Application no: **3/2021/1021**

Address: **4 Kayley Terrace Main Street Grindleton BB7 4QX**

Proposal: **Proposed change of use of the ground floor from Class C3 to Class E; from a two bedroom terrace dwelling to a ground floor Local History archive and meeting room and a single bedroom flat on the first floor.**

The Local Highway Authority have viewed the plans and highway related documents and have the following comments to make:

Title: **Scheme drawing** Drg N° **506/1/2**

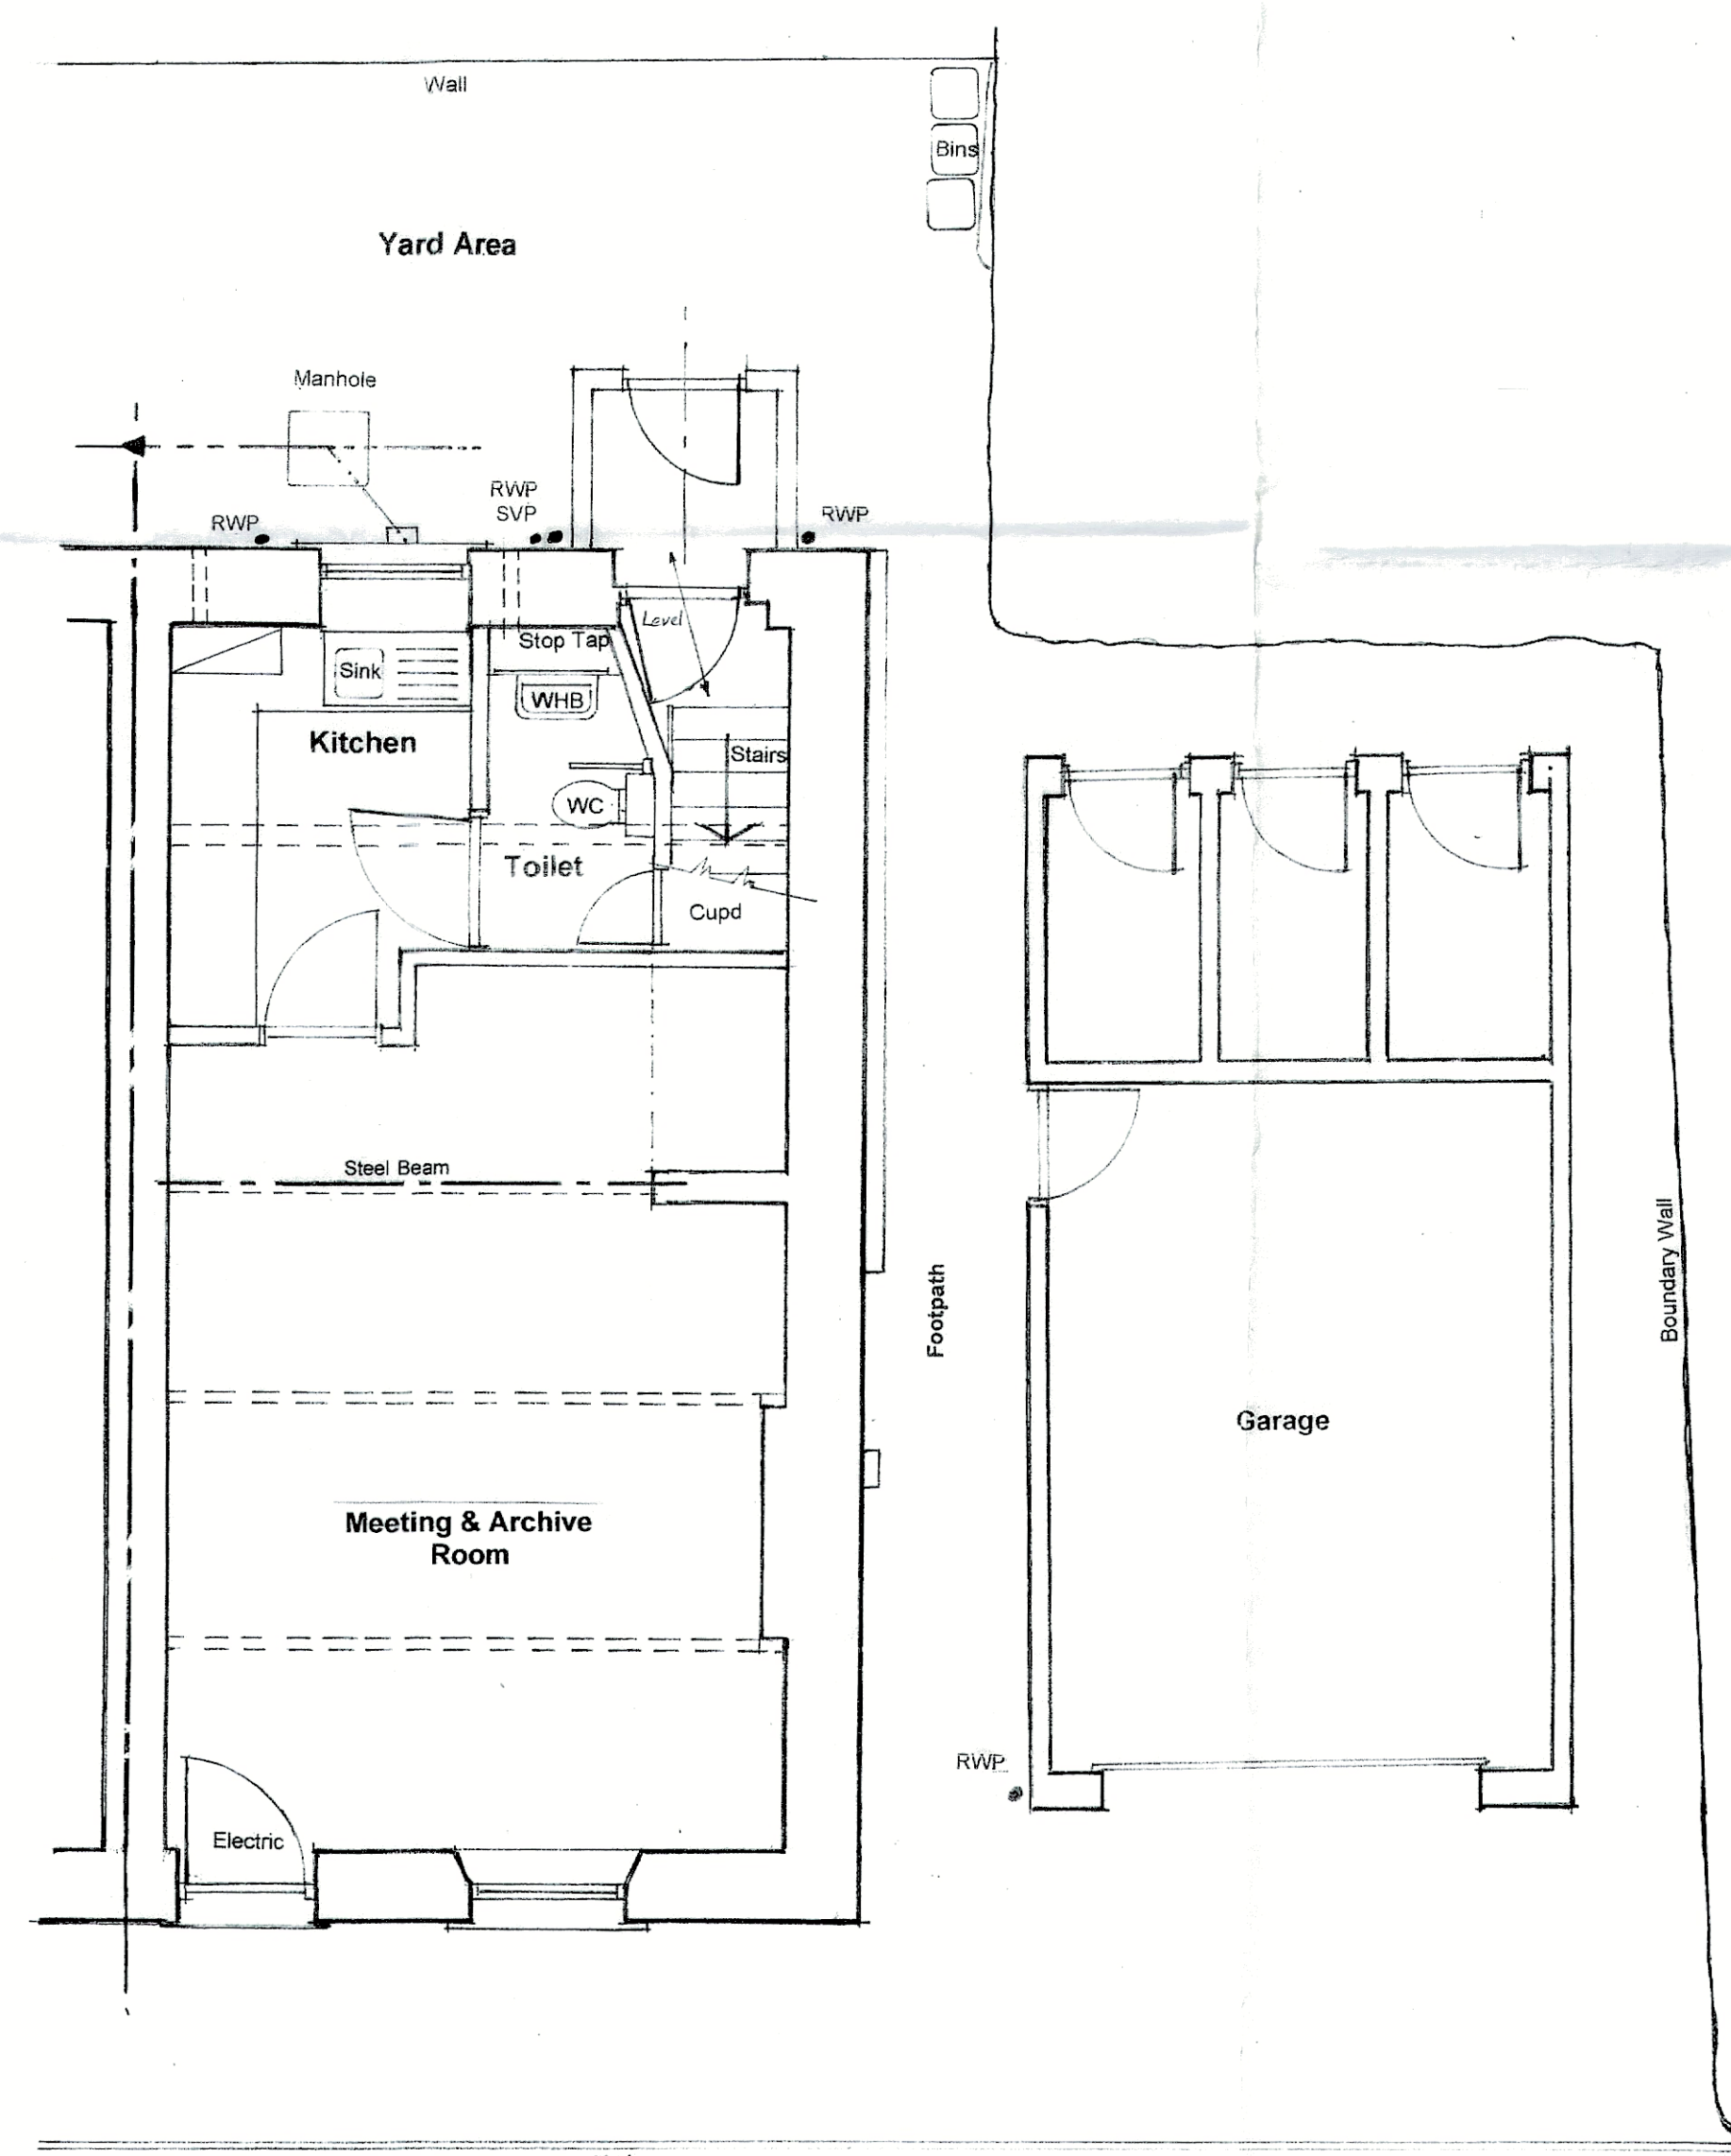
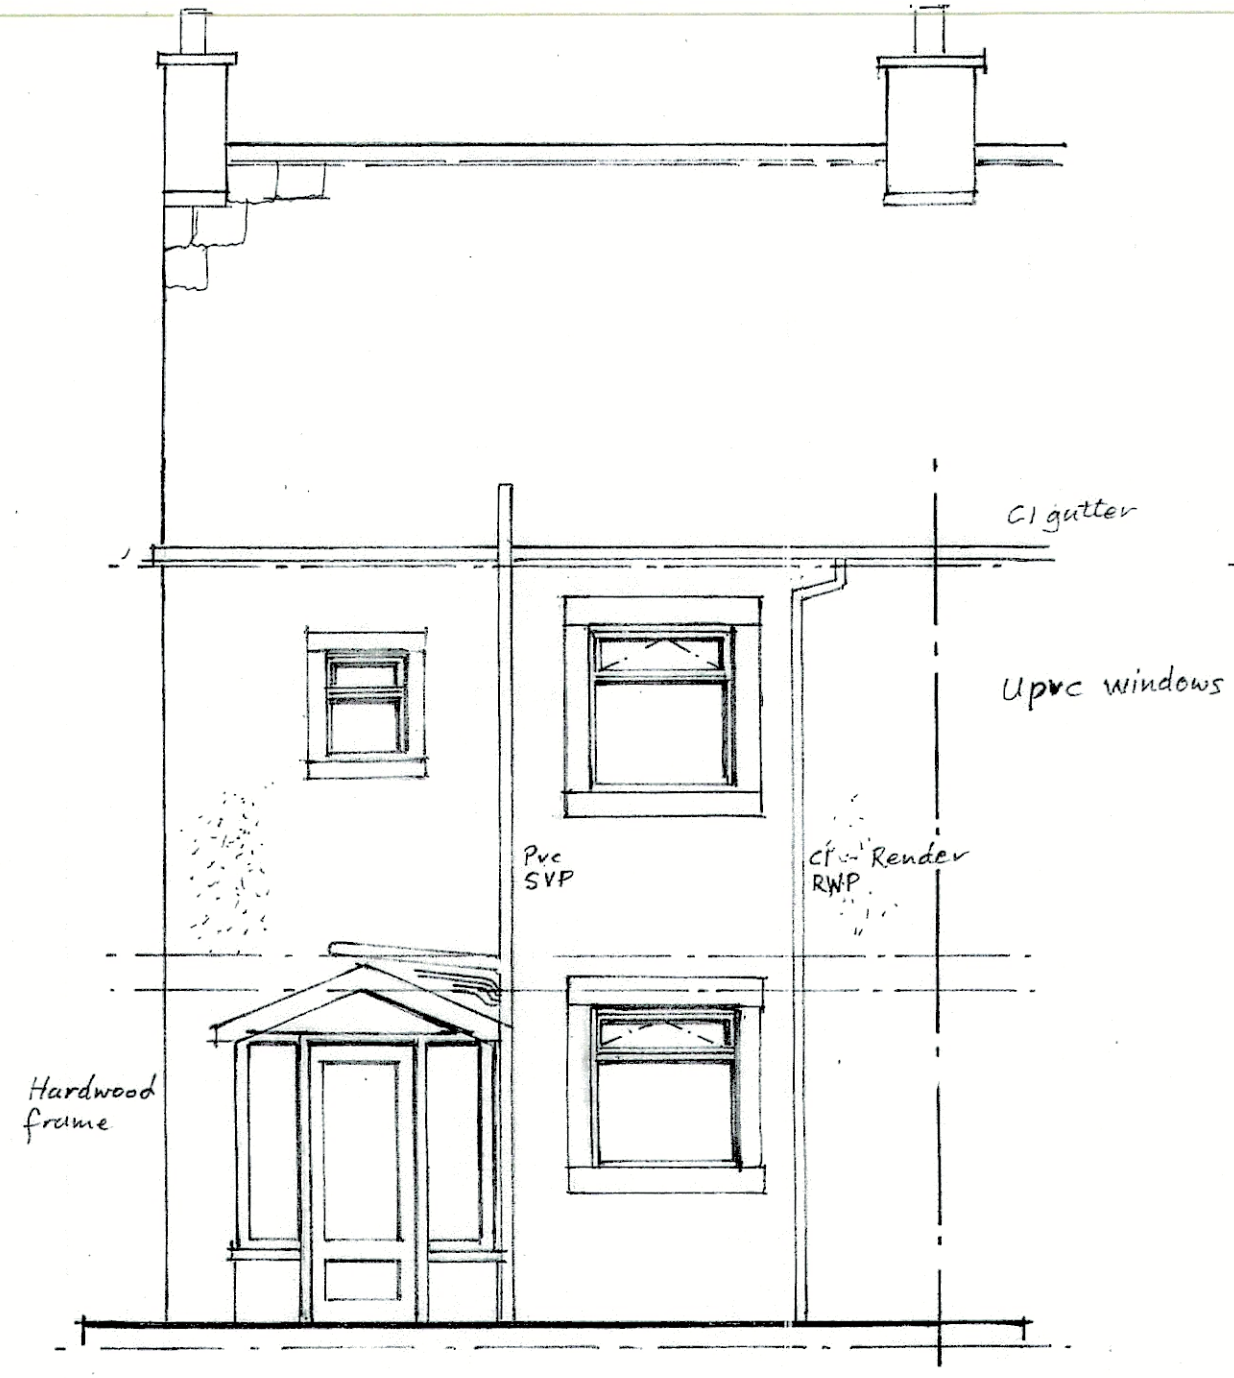
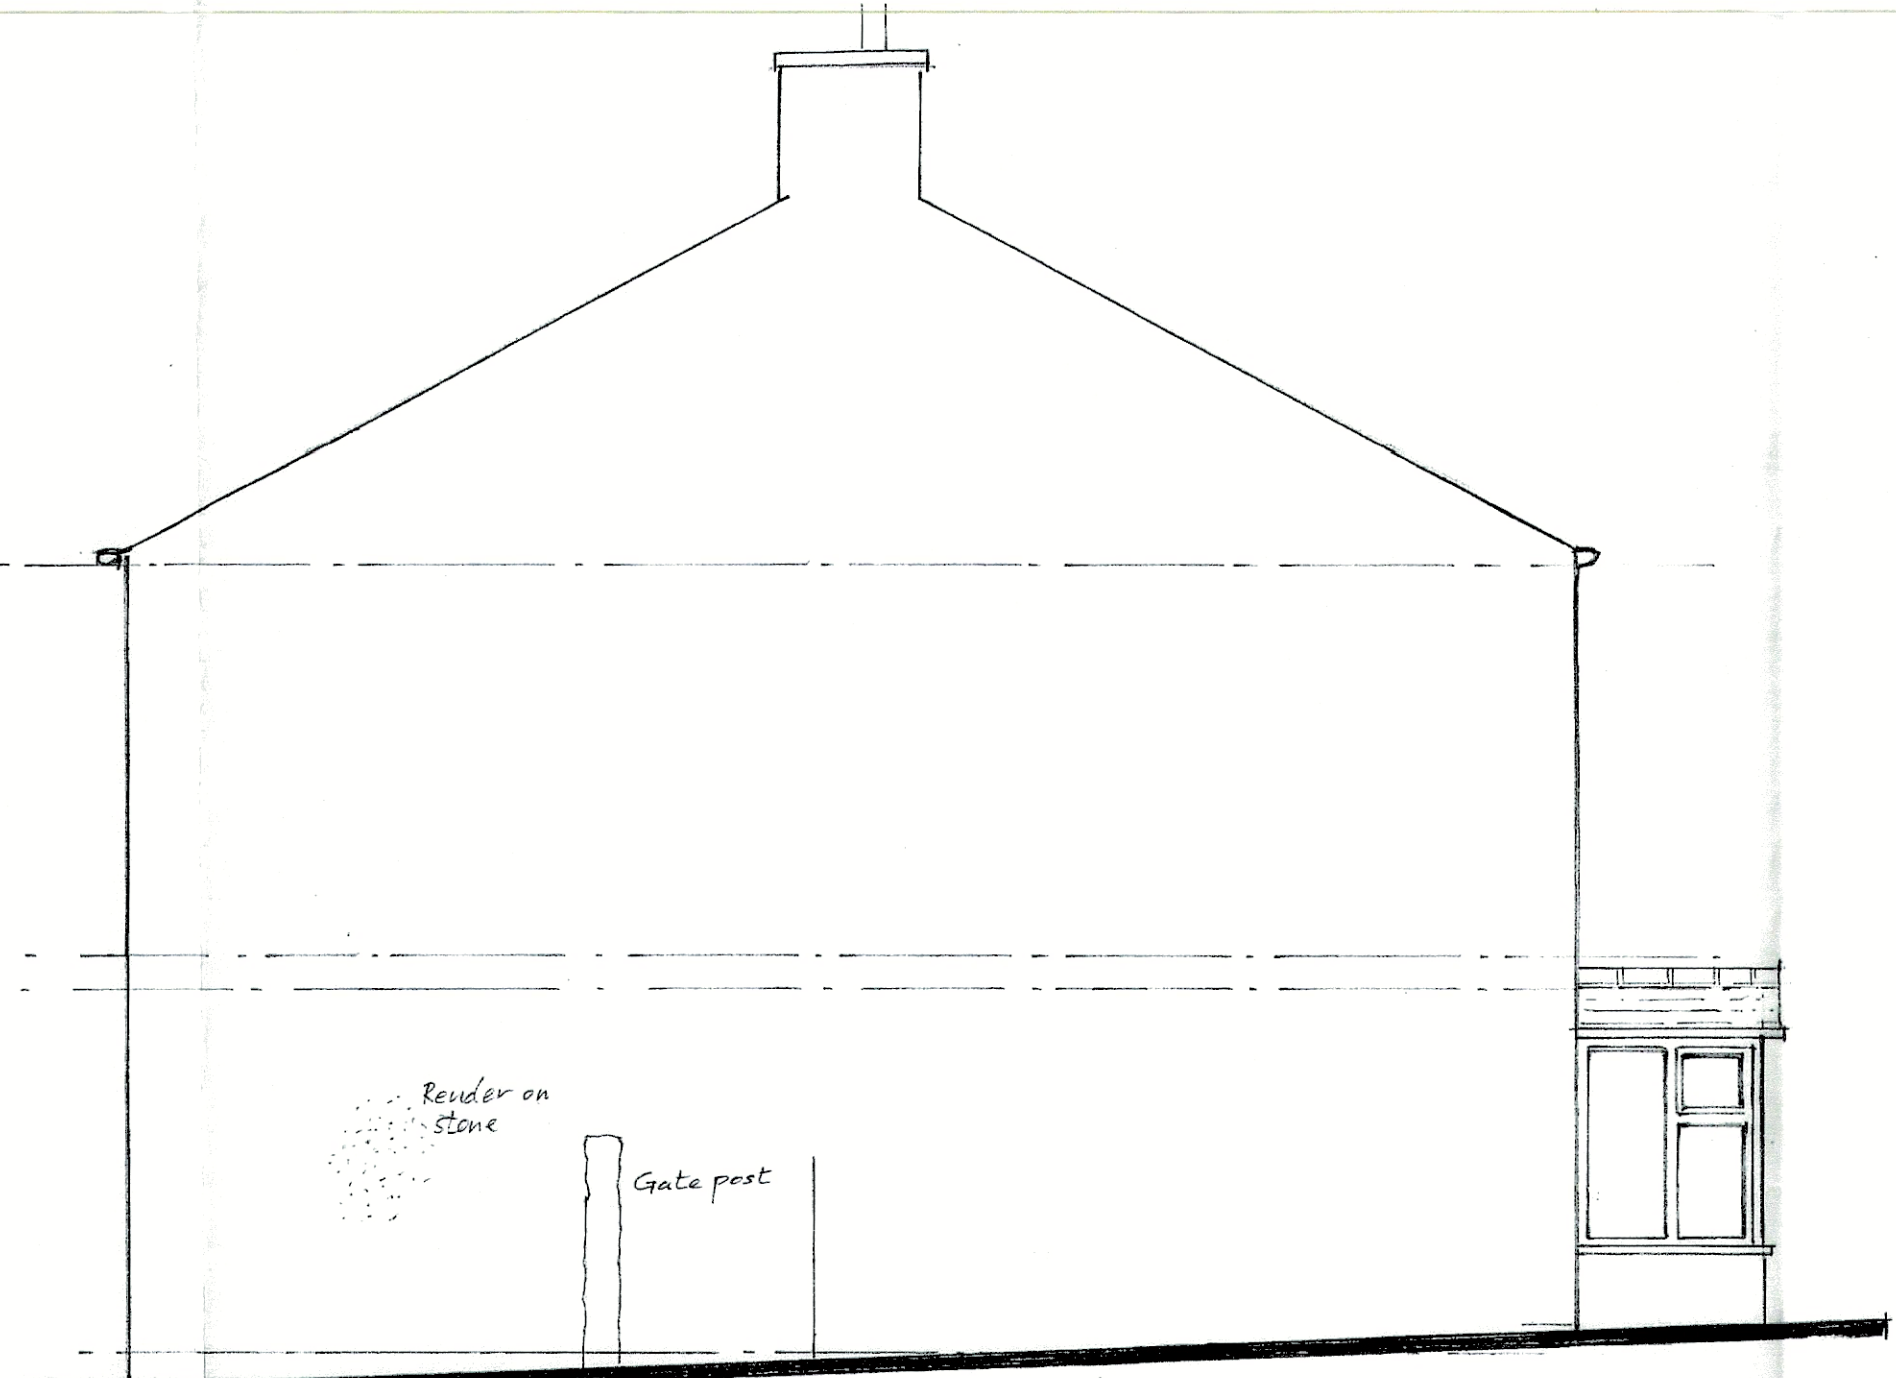
However, the site can only provide one car parking space in the existing single, detached garage and even then, the internal dimensions do not comply with the LHAs guidance, as shown on Jeff Marshall and Associates drawing number 506/1/2 titled "Scheme Drawing", with the LHA requiring a single garage to have the minimum dimensions of 6m x 3m.

However, before the LHA can consider the shortfall in parking at the site with there being a shortfall of 5 car parking spaces for the Local History Archive and meeting room element of the application, the LHA require an Operation Statement stating, *"who will use the meeting room and the Local History Archive; where these people will travel from and how; and the expected trips generated to the site on a daily basis"*. This information will allow the LHA to consider the parking demand at the site.
